# PORTLAND MAINE

January 26, 2005

RE: Application for Single Family Residence, Country Lane, lot #4

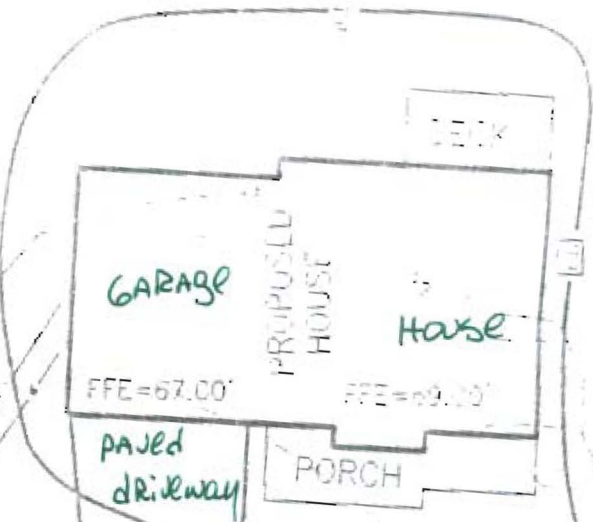
1. The site plan submitted is not approvable because it does not conform to the subdivision approval.
  - a. In particular, there are wetlands on the lot that are intended to remain preserved. Your site plan does not indicate the locations of these wetland areas. The plan also shows proposed topography/filling in these areas. In researching the Pheasant Hill Subdivision approval, the planning board report states that the lot buildouts were designed to minimize the amount of wetland filling, thus not requiring approval from the U.S. Army Corps of Engineers. Also, your proposal may require amending an existing permit with the Department of Environmental Protection.

- b. The driveway/curb cut relocation is not approvable because the approved and built-out location was also done so that wetland disturbance would be minimized.

- c. Additional permitting may be required by the Maine D.E.P. to cross the wetlands with the proposed utilities.
